Submission No.			190	
Organisation Name or Name of Submitter			Michael A Doyle and Carmel Smith Doyle	
Item No.	Section Ref.	Page No.	Observation Statement	TII Response
Re: Metrolink Railway Order 2022, Estuary to Charlemont, Reference Number NA29N.314724				
1	Letter	1	<p>I live at 34 Dartmouth Road.....</p> <p>Firstly, in general, I am in favour of the broad aim of the Metrolink project to connect Dublin’s city centre to our national airport.</p> <p>However, as a resident living in the Dartmouth/Charlemont area, I wish to set out a number of observations, for the Board’s consideration, regarding the proposal to locate the Terminus station at Charlemont-Dartmouth.</p> <p>My family home is in the midst of the community where the Terminus station at Charlemont is proposed to be located, and is dangerously close to the proposed very deep pile insertions and deep station box excavations.</p> <p>I would request that An Bord Pleanála give very serious considerations to the important issues raised in this submission, and, in consequence, mandate Planning Conditions appropriate to the nuisance value inherent in this application for a major transport hub located in a heretofore quiet Victo

CHARLEMONT STATION - CROSS SECTION

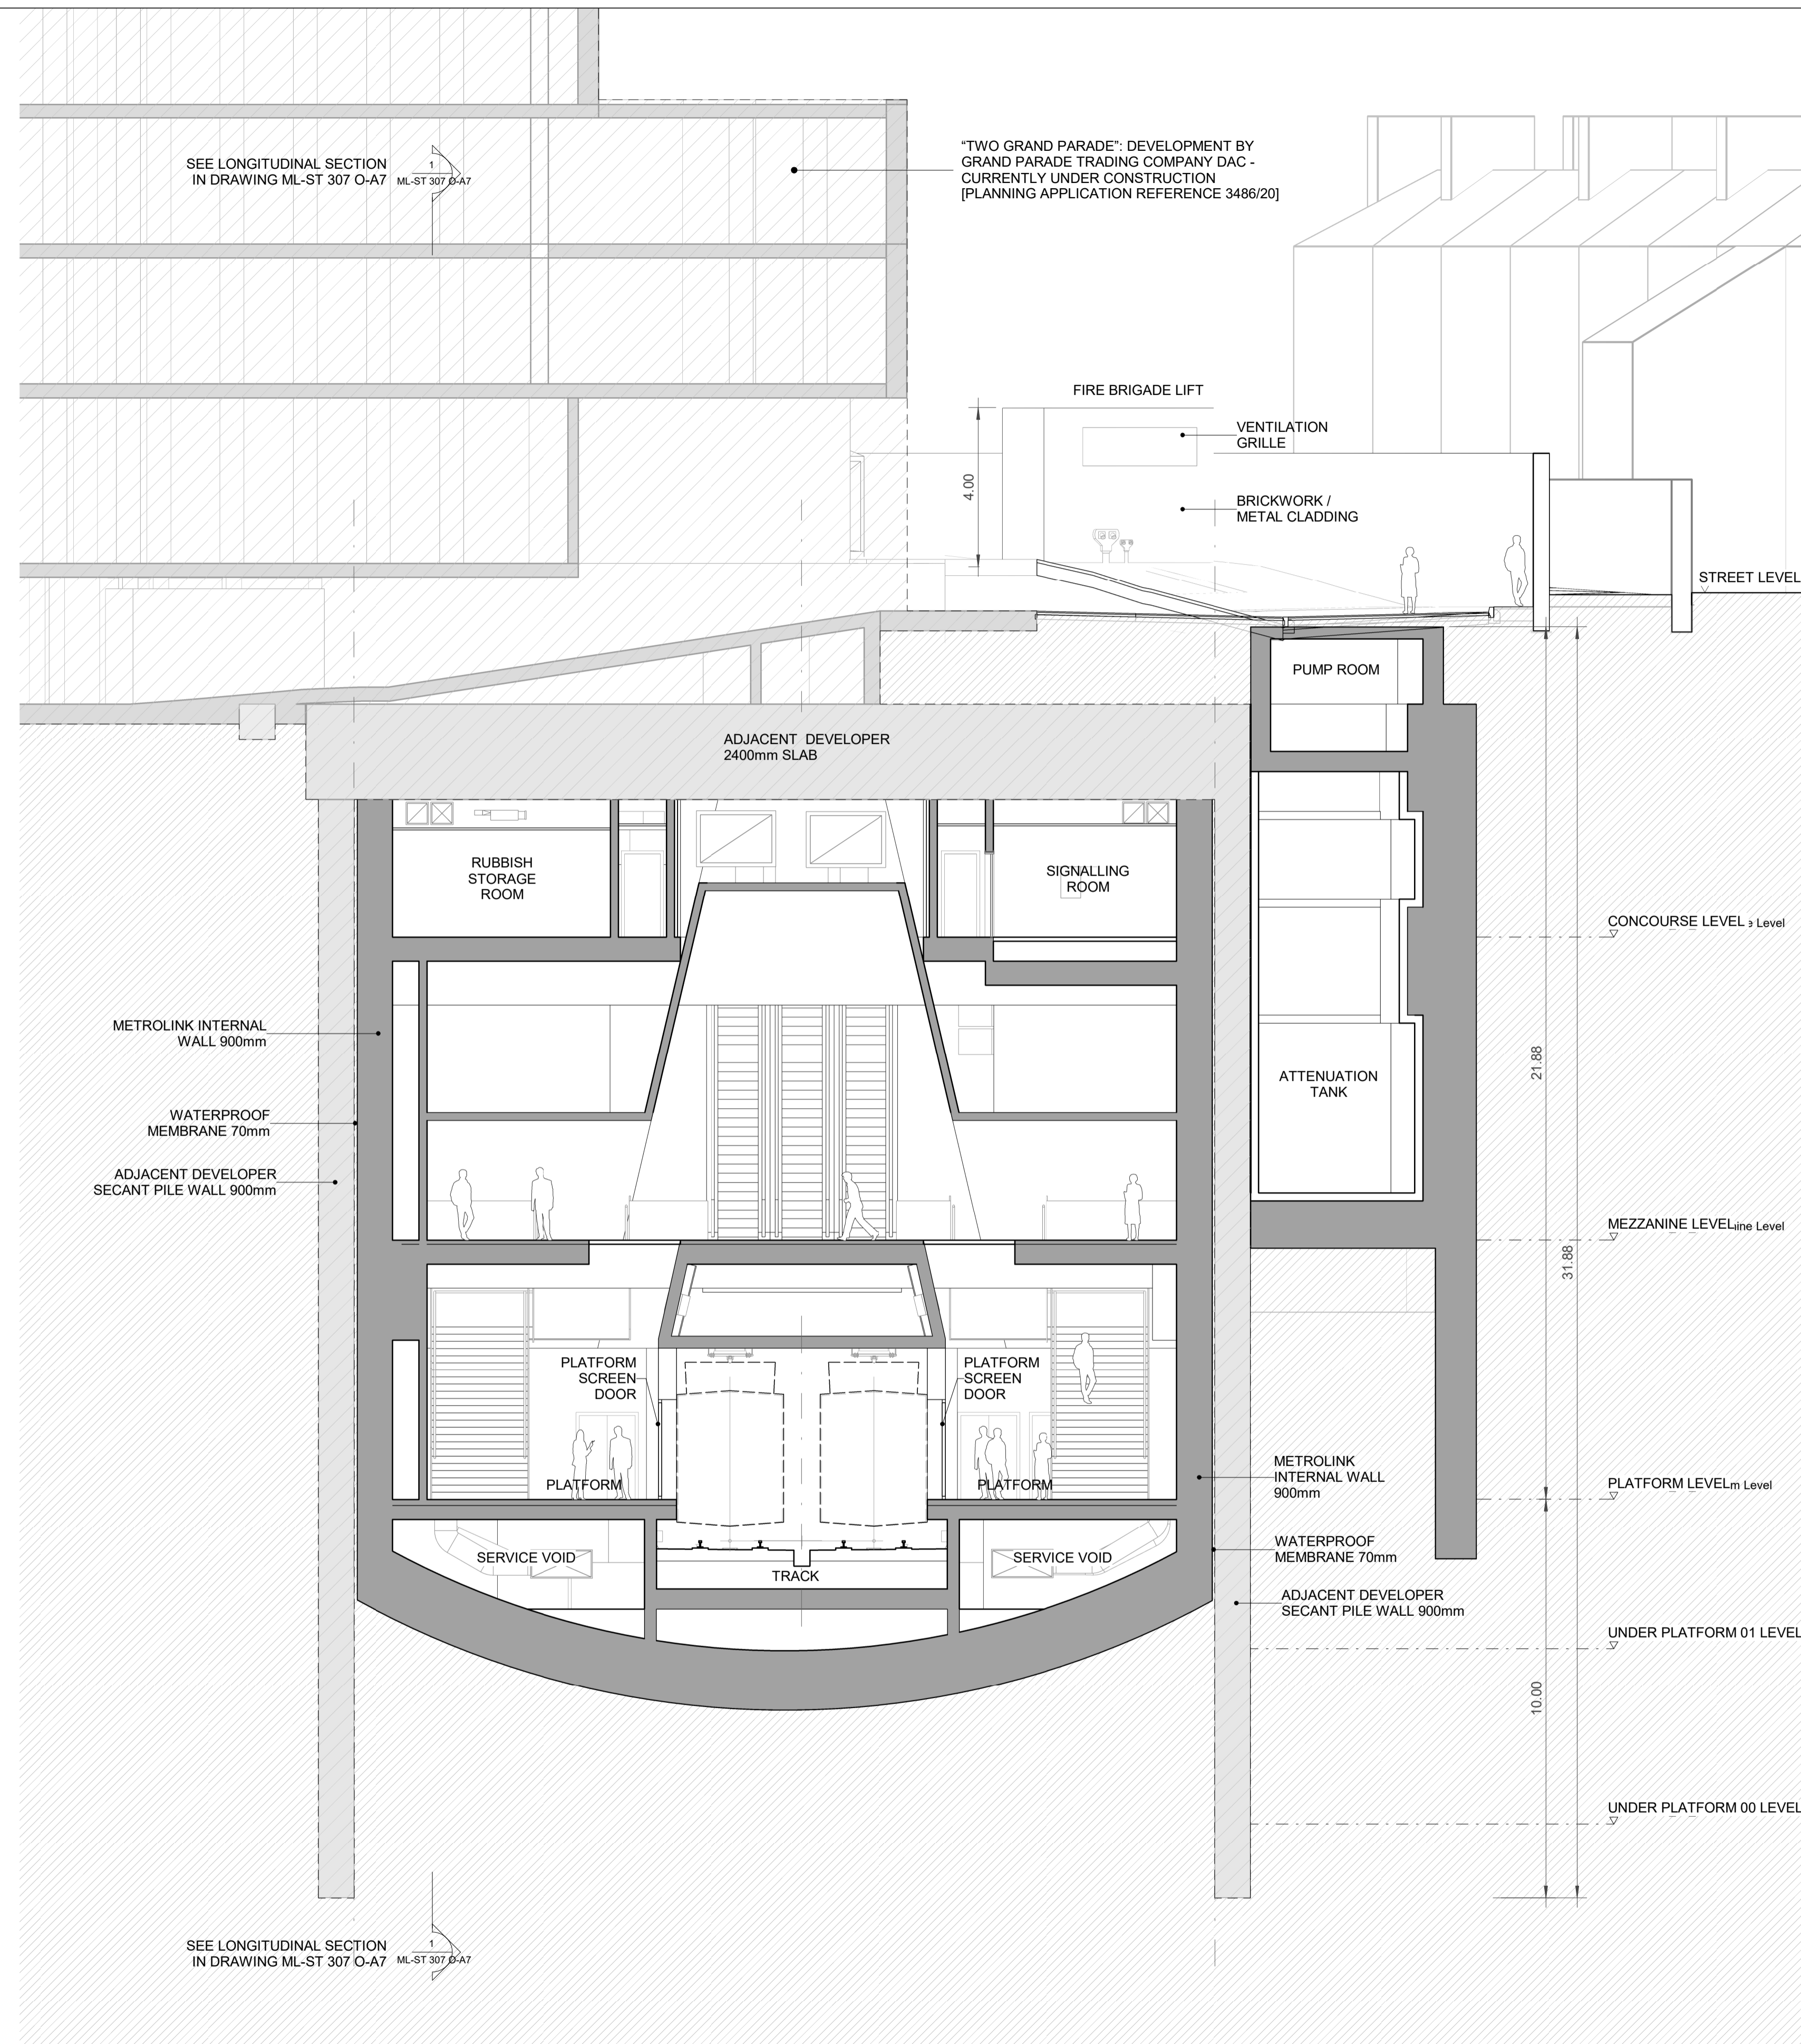
6	SETTLEMENT, SUMMARY	6	<p>1.1 ACCURACY OF DEPICTION OF BORED PILES ON DARTMOUTH ROAD, Drawings do not accurately reflect actual position of bored piles.</p>	<p>The drawings do depicted the location of the station structure in relation to Dartmouth Road. Please refer to the submitted Railway Order drawings, Structures Details, Book 2 of 3, drawing ML1-JAI-SRD-ROUT_XX-DR-Z-02090, which indicates the outline of the station external walls (Diaphragm Wall piles) in relation to the properties along Dartmouth Road.. The EIAR Chapter 5, MetroLink Construction Phase, Section 5.10.13 and Appendix A5.3 Section 8.14, also indicates the position of the station wall and explains the proposed construction of Charlemont Station.</p> <p>Further information of the depth of the proposed station structure is provided on station floor level structural plan drawings ML1-JAI-SRD-ROUT_XX-DR-Z-02092 to 02095 together with associated longitudinal section Drawings ML1-JAI-SRD-ROUT_XX-DR-Z-02096.</p>
